LOCATION:  
Bent Grass Meadows Dr. &  
Meridian Rd; Falcon, CO 80831

JOB NAME:  
LC LIFE.CHURCH  
(East Elevation)

Within 300 Feet of Lot Line: South Elevation

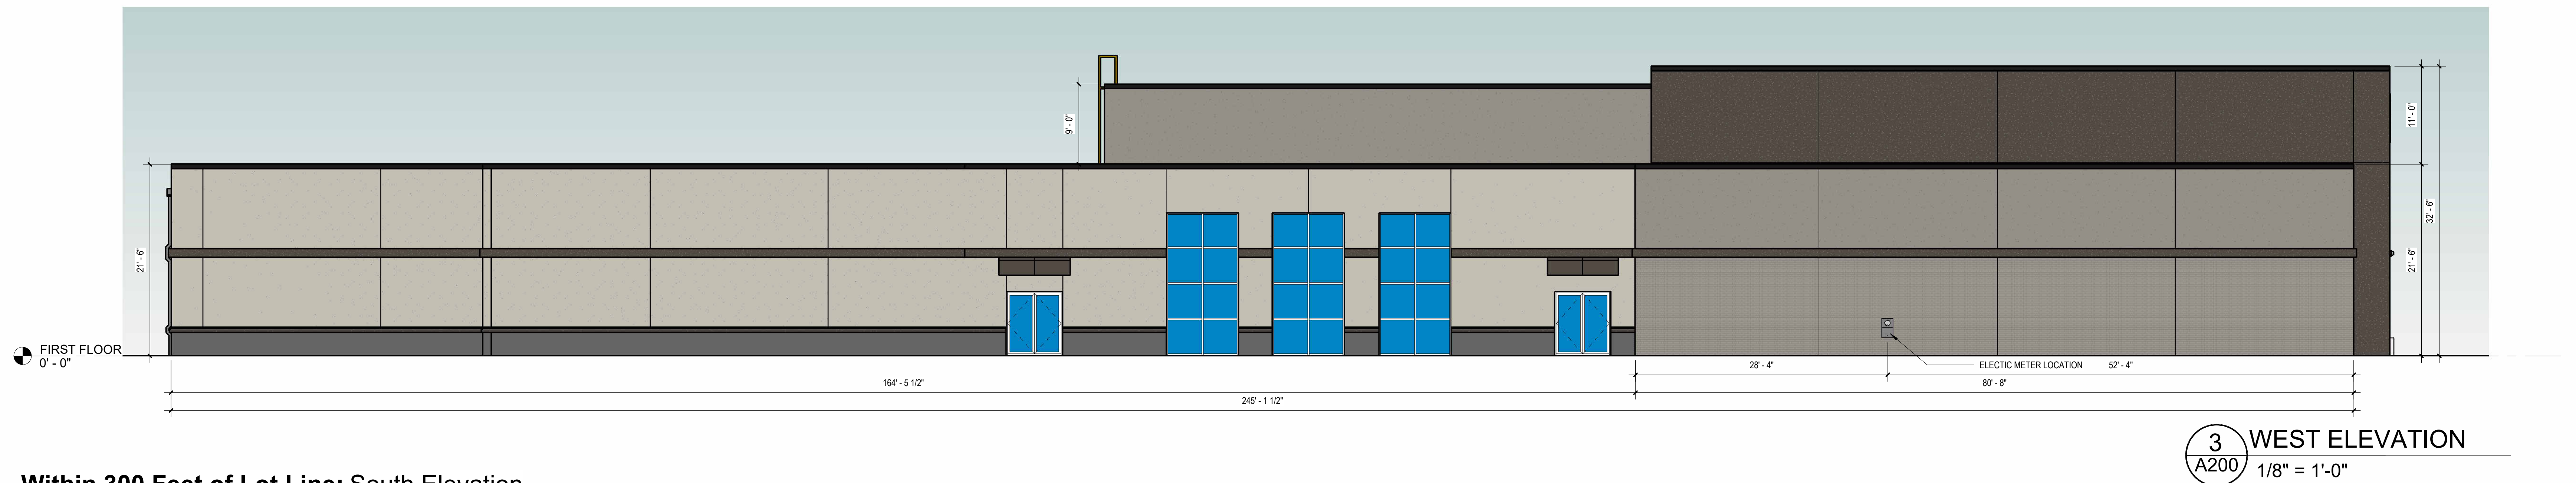
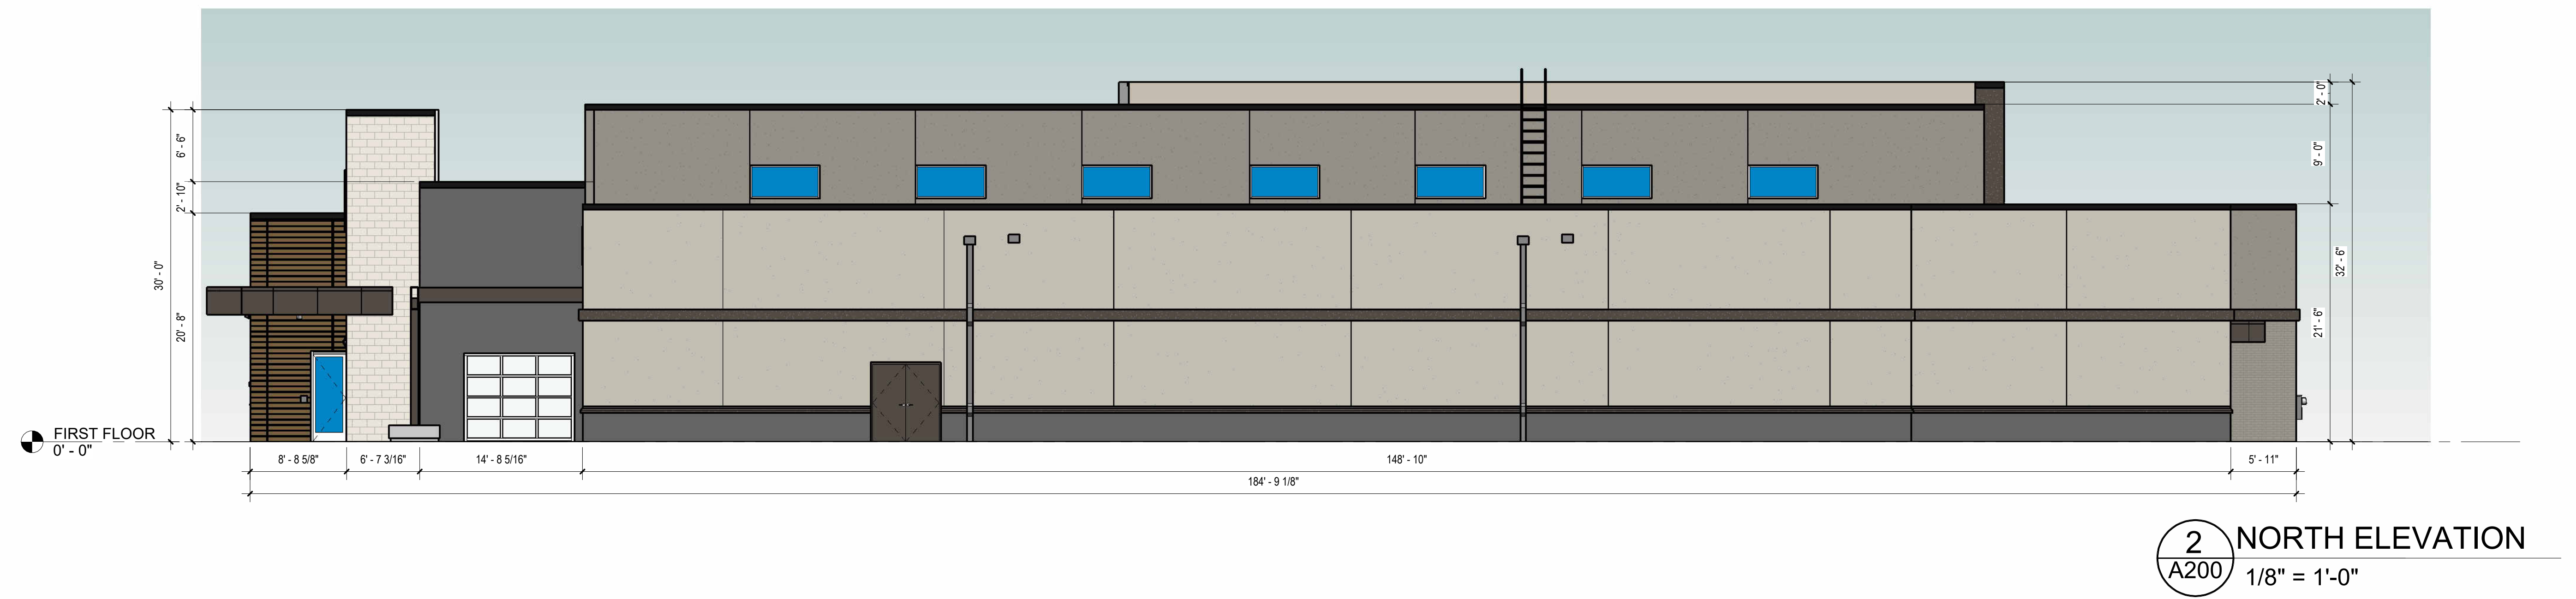
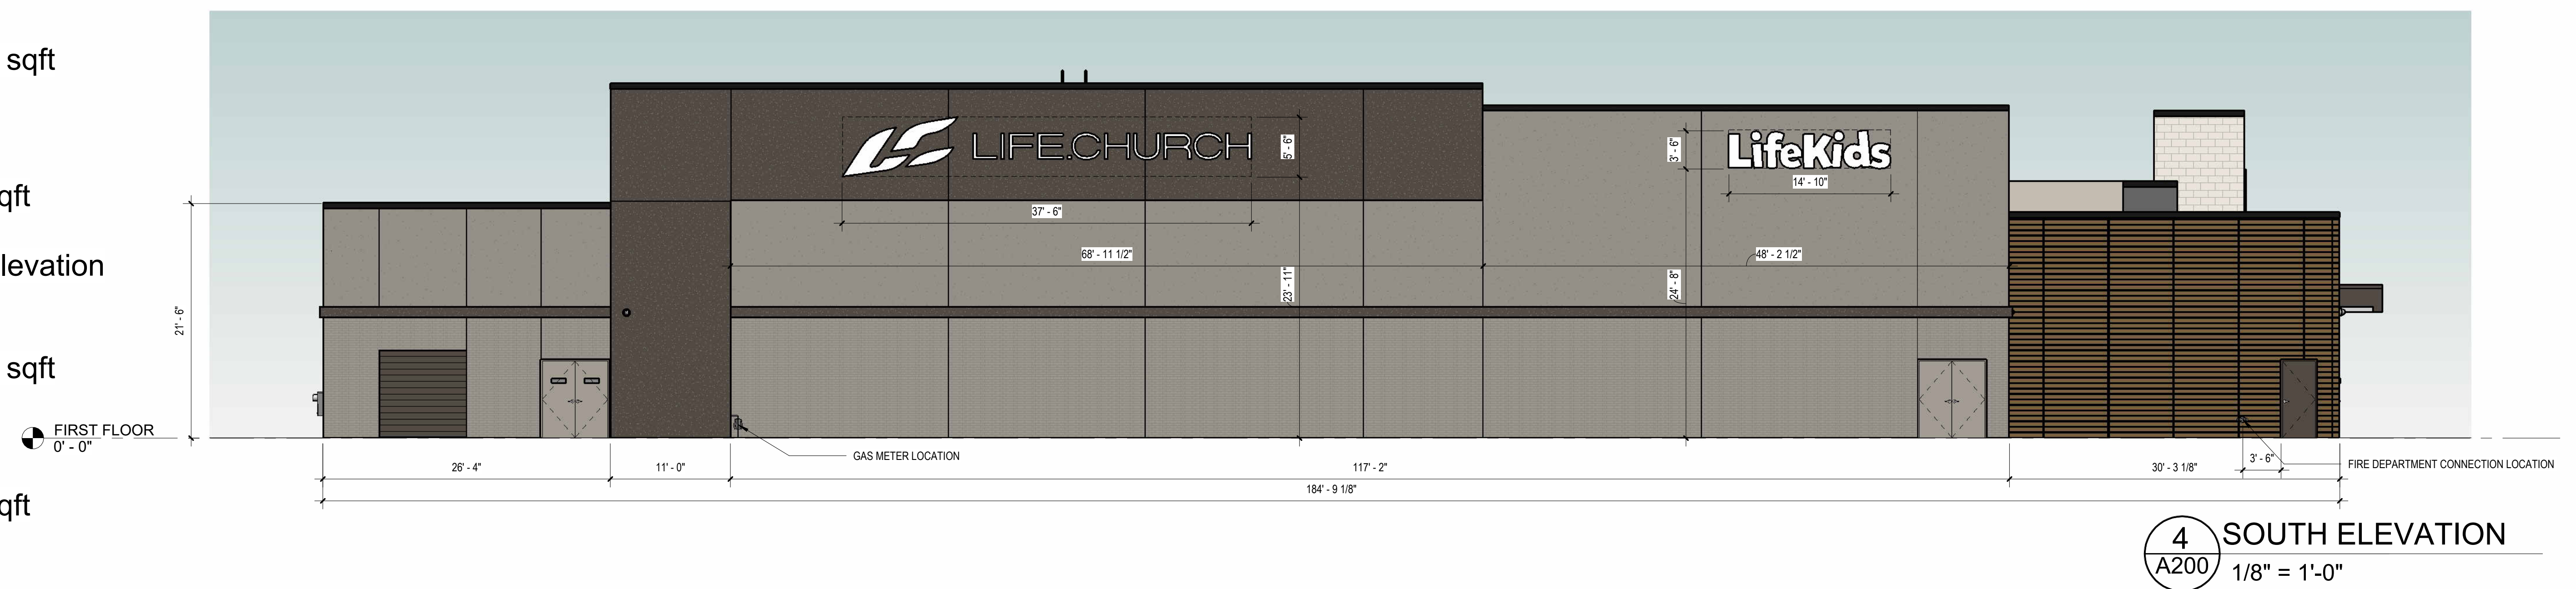
Please provide sign size calculation per Chp6.

1 EAST ELEVATION
A200 1/8" = 1'-0"

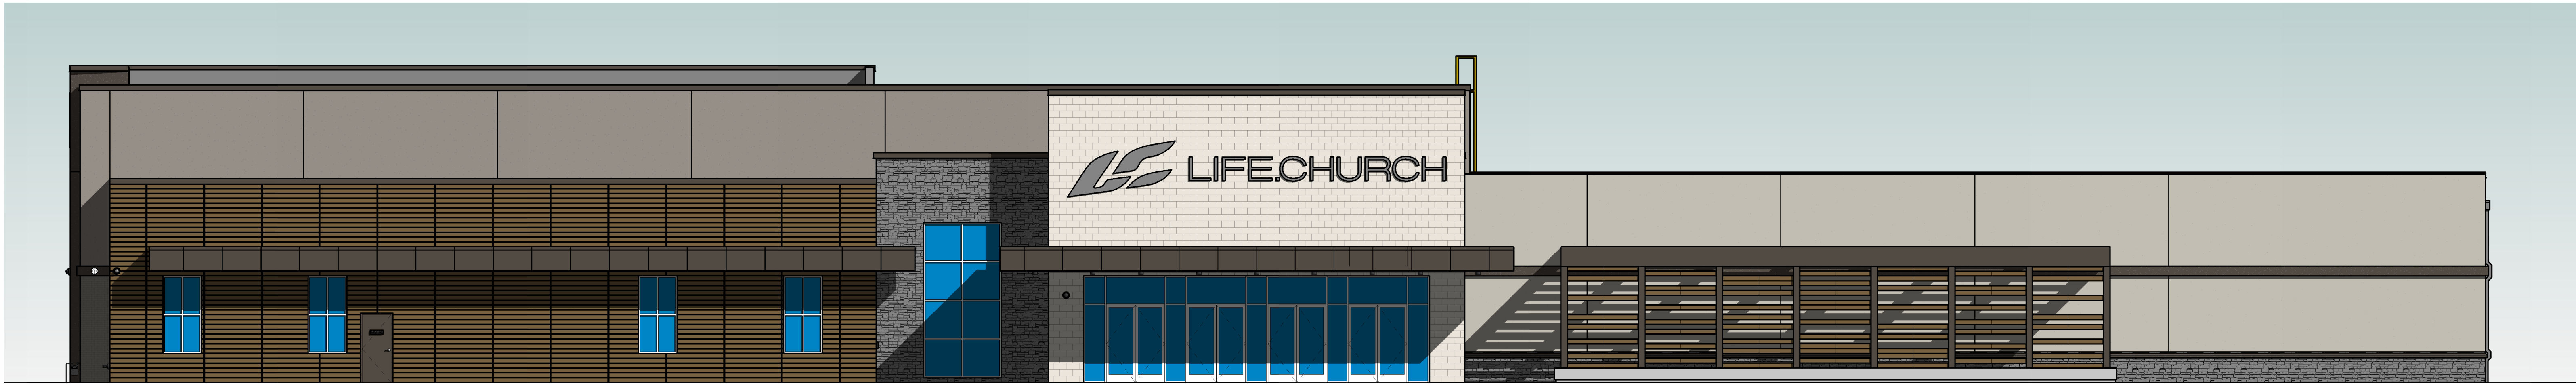
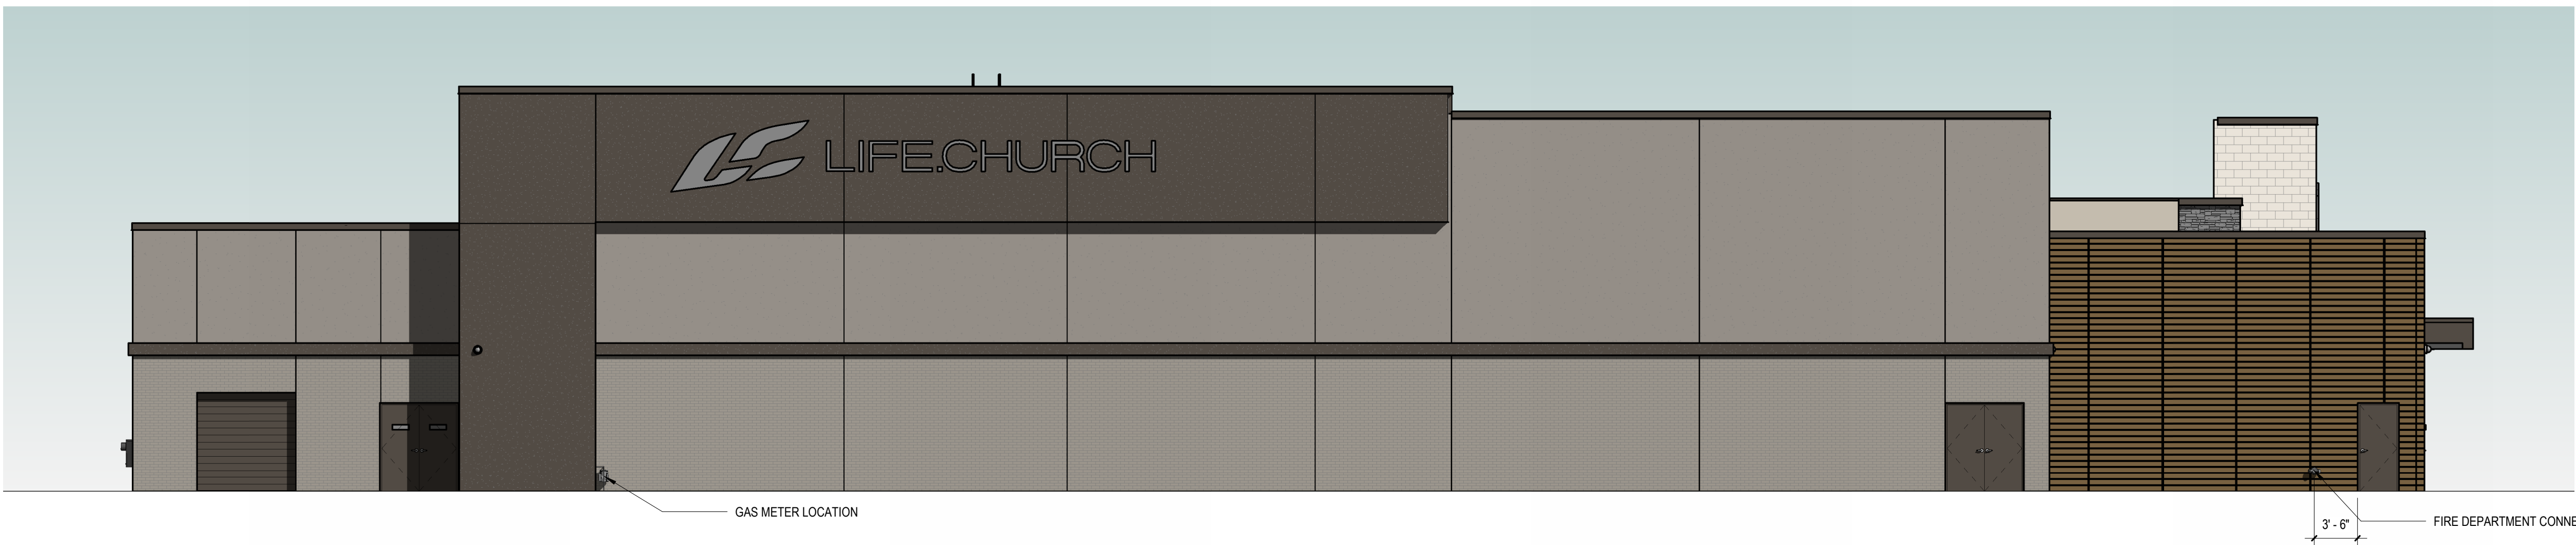
Full building elevation data is required to review sign plan.
